Land Use Planning
Yorkshire Water Services Ltd
Midway
Western way
Bradford
BD6 2LZ

Your Ref: 2020/93308
Our Ref: W014055

17th November 2020

Former Spotted Cow Pub, New Hey Road, Huddersfield - Erection of an A1 foodstore with associated parking, servicing areas and landscaping

DRAWN	KK	DATE	22/07/2019
CHECKED	TM	SCALE	
APPROVED	KGP	AS SHOWN @	A1
DRAWING NUMBER	09-122-502		REVISION
			E

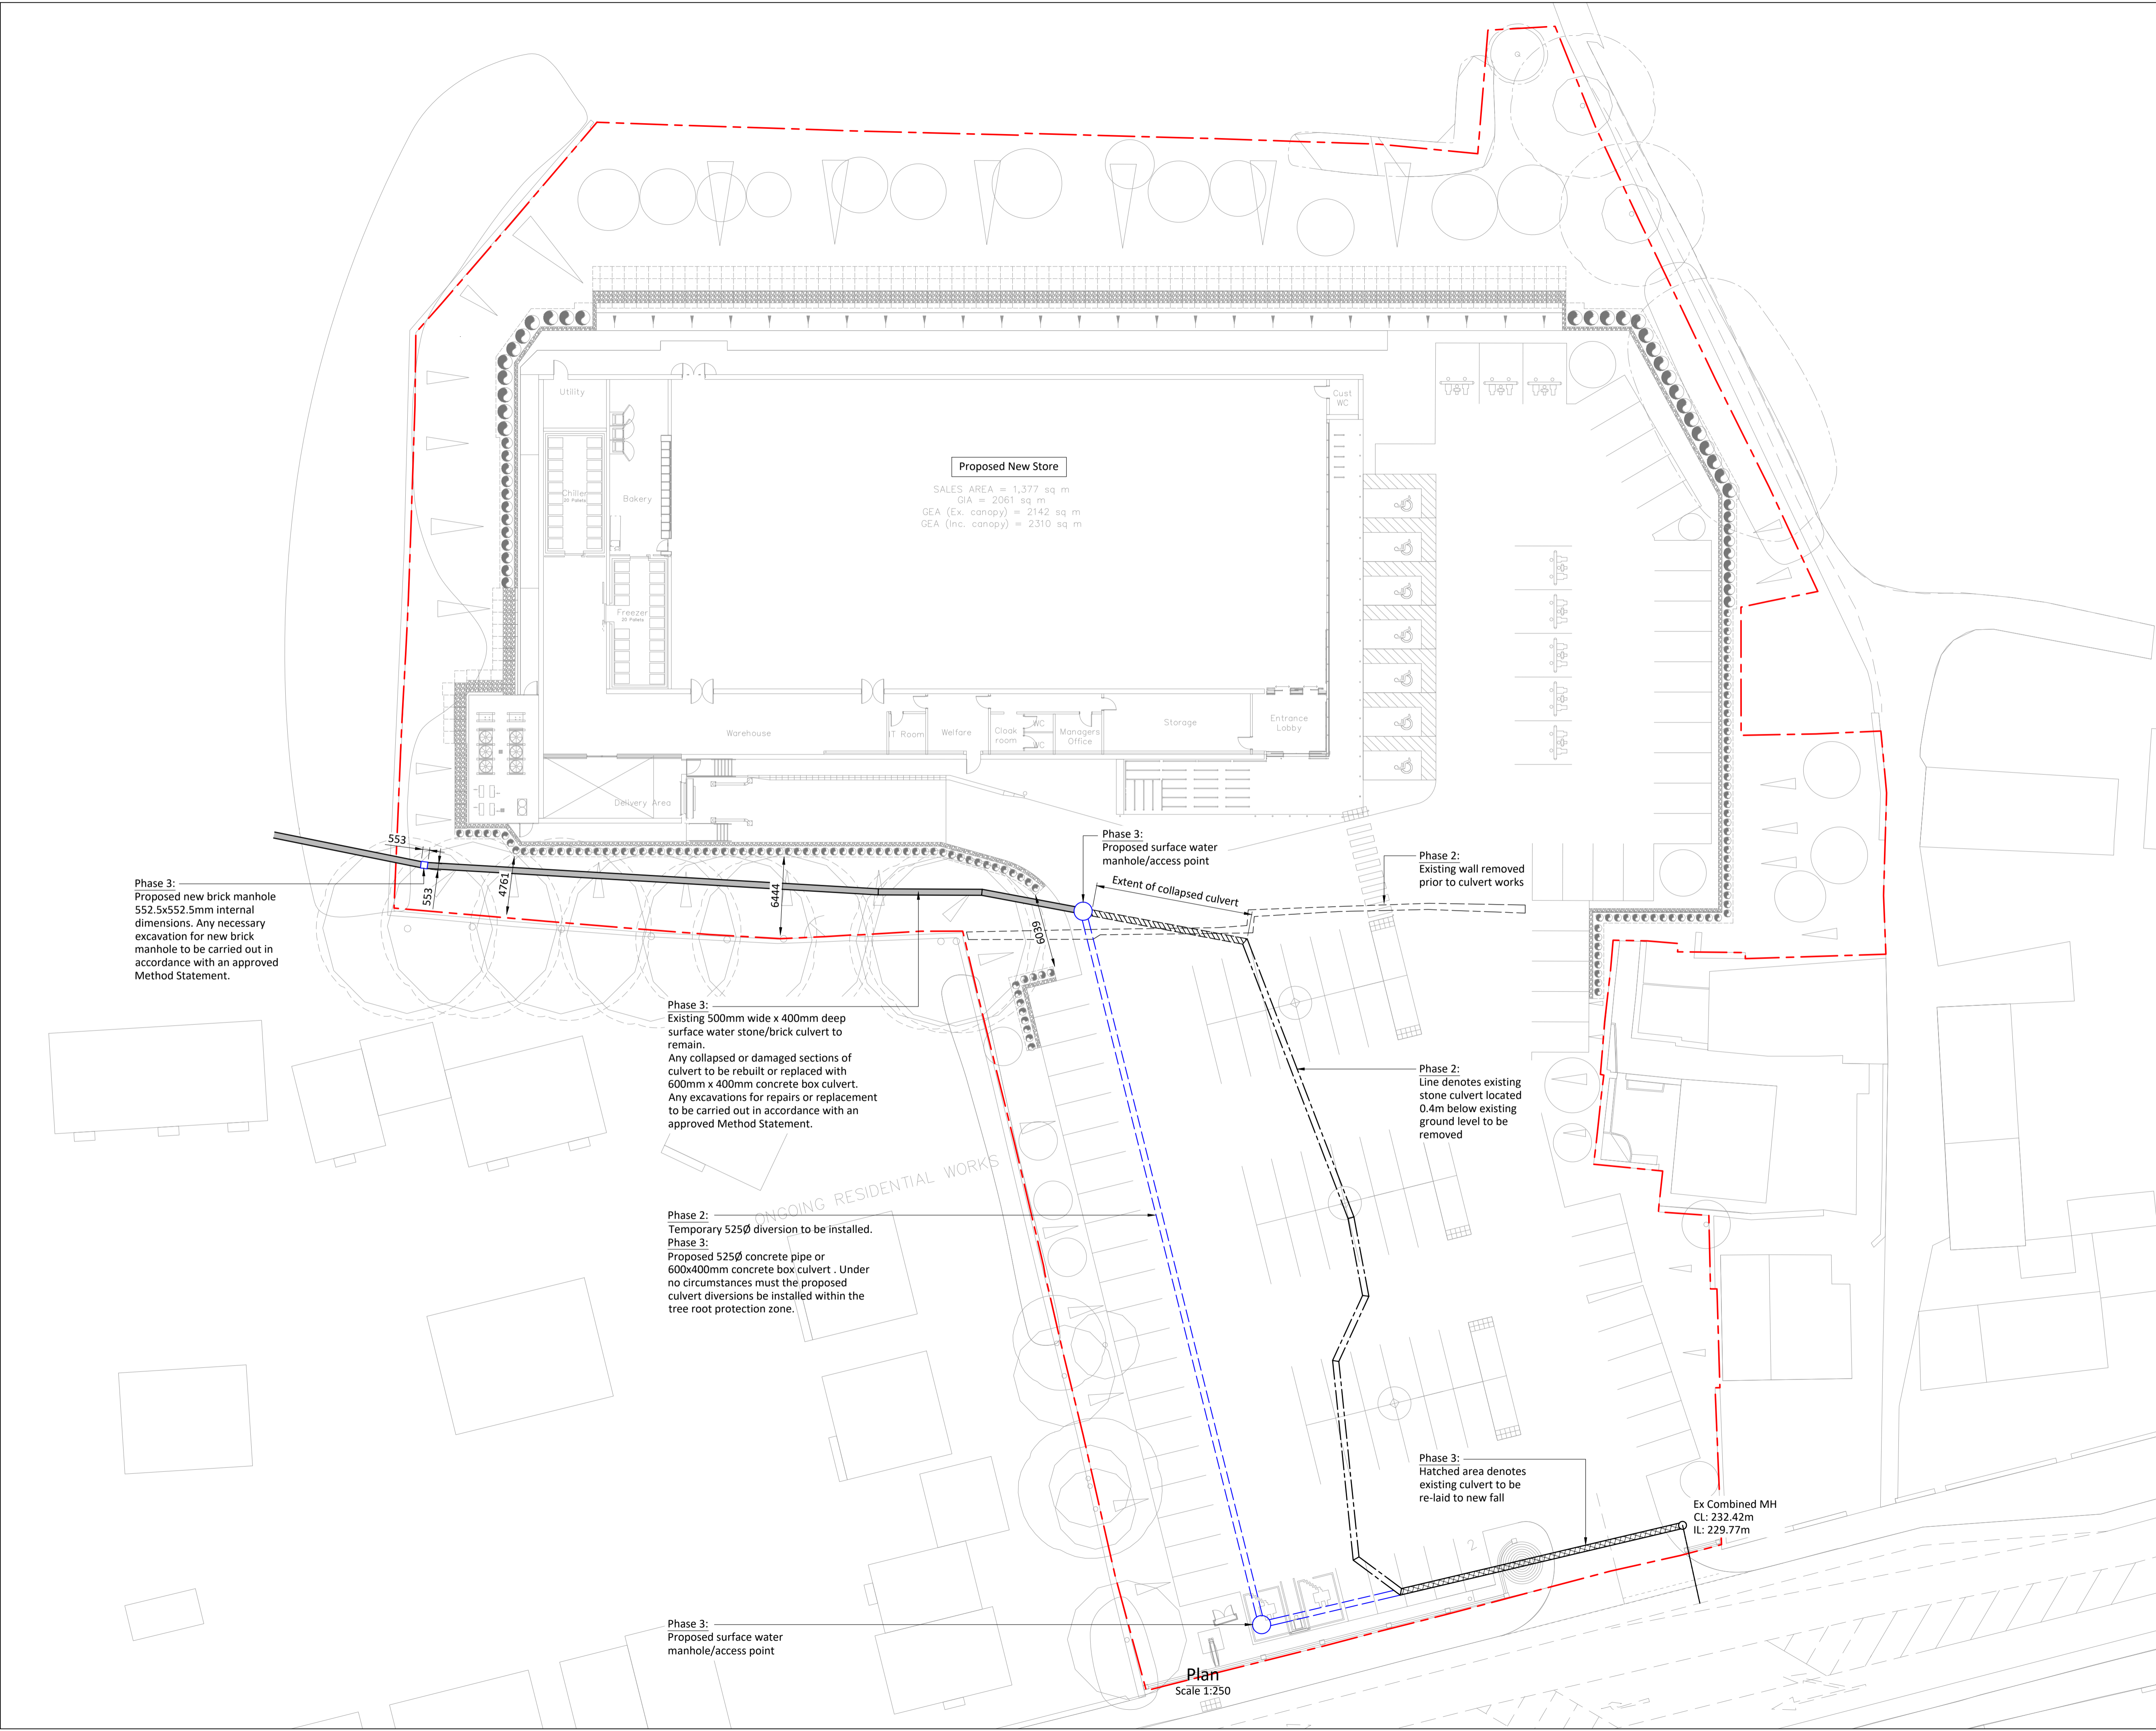
The drainage details submitted on drawing 09-122-502 (revision E) dated 21/09/2020 that has been prepared by Beam Consulting require amendment, but if planning permission is granted, the matter can be dealt with via condition. The following points should be addressed:

1) the submitted drawing appears to show a culvert diversion which ultimately discharges to the public combined sewer network.

2) the culvert diversion must not result in any increased flow rate from the culvert to the public sewer network.

3) The developer will need to prove existing culvert flow rates and the proposed diversion flow rates as evidence that there will be no increased discharge to the public sewer network.
